Re: Selhurst – No 5 Dagmar Road SE25 6HZ
Section 73A(2)(c) Planning Application to vary Condition 2 relating to Planning Permission Ref 21/01032/FUL

Accordingly, we are instructed to apply to update the drawing references referred to within Condition 2 via a Section 73A (2) (c) application, which seeks to ensure that the development is built out in accordance with approved details.

PROPOSED SECOND FLOOR PLAN  
(LOWER DUPLEX FLOOR)

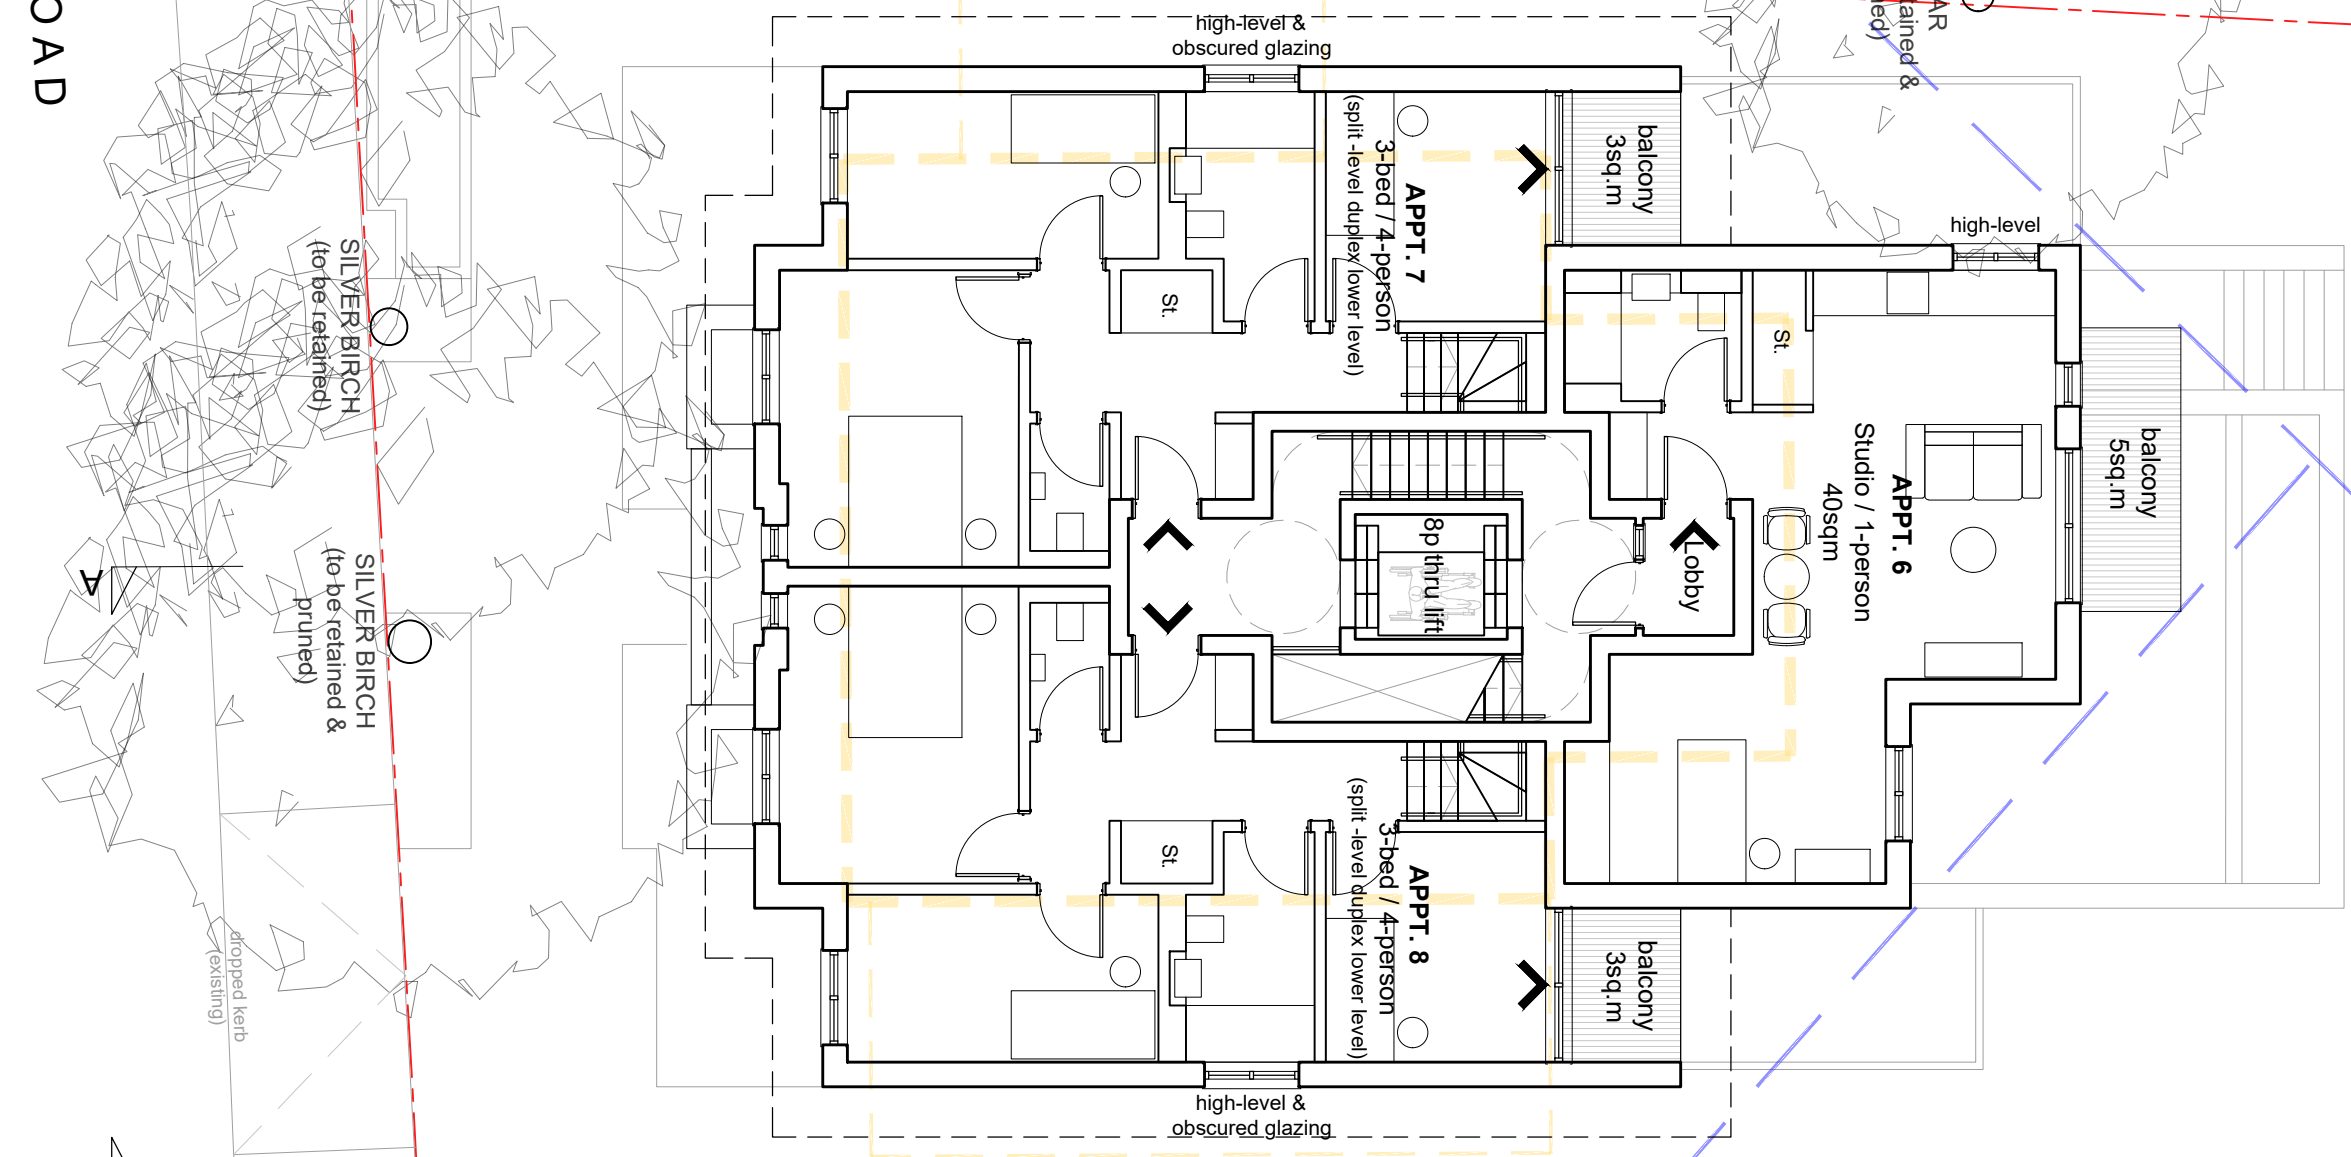
Positioned at second and third floor level Units 7 and 8 are duplex 3 bed/4 person smaller family sized dwellings that previously benefited from a private amenity area of 9.5 sqm each.

Whilst this meets the requirement of Local Plan Policy DM10.4 (which requires a minimum of 5 sqm per 1-2 person unit and an extra 1 sqm per additional occupant thereafter), it is noted that this amenity space is split with just 6.5 sqm being accessed from communal living areas and the remaining 3 sqm being accessed solely through the lower level bedroom.

**PROPOSED THIRD FLOOR PLAN
(UPPER DUPLEX FLOOR)**

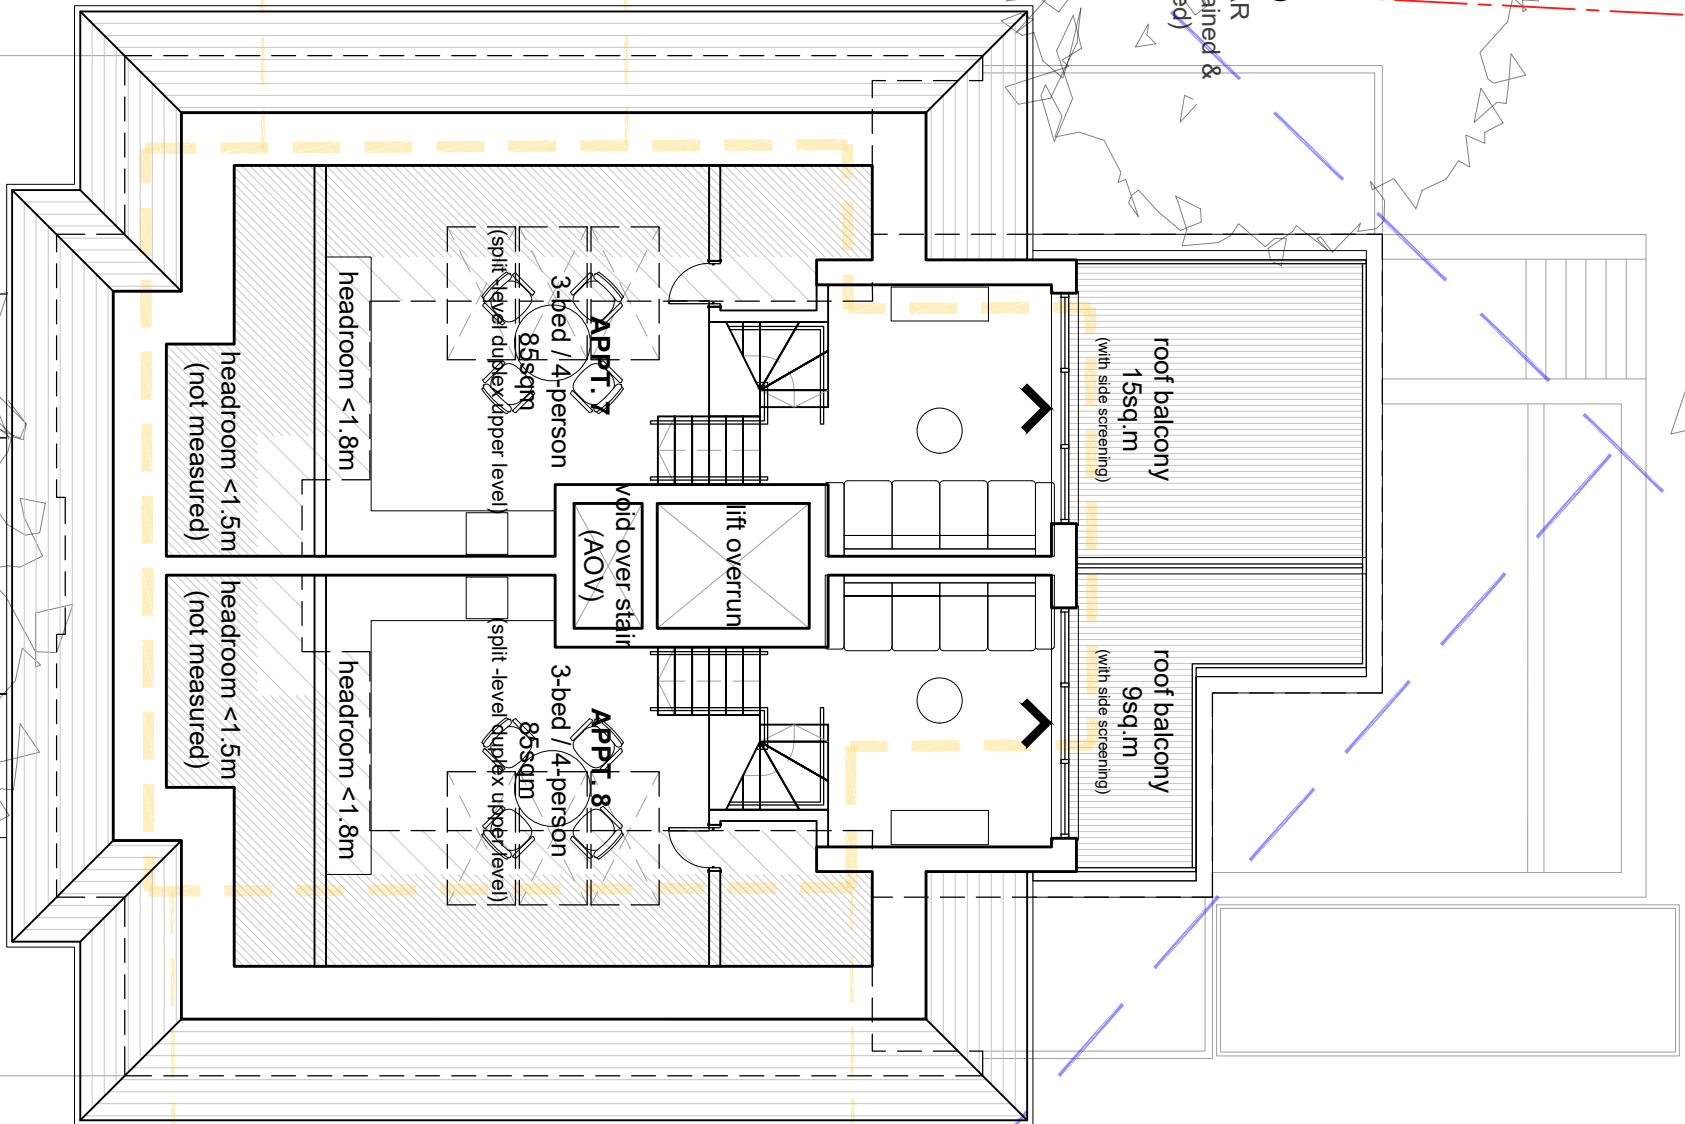
Accordingly, this proposal allows for an increase in the proposed amenity areas of Units 7 and 8 from 9.5 sqm to 18 sqm and 12 sqm respectively, of which 15 sqm and 9 sqm will be accessed directly from the third floor communal living area.

The balconies of Units 7 and 8 are proposed to simply extend a further 2.5 metres north eastwards over the existing building footprint. Accordingly, they will continue to successfully integrate within the approved rear elevation and give rise to no reduction in the overall external design quality of the building.

Importantly, as confirmed within the enclosed drawings package the enlarged balconies will continue to respect the 45 degree views of neighboring properties to the west and east with 1.8 metre high privacy screens proposed as per the approved application Ref 21/01032/FU.
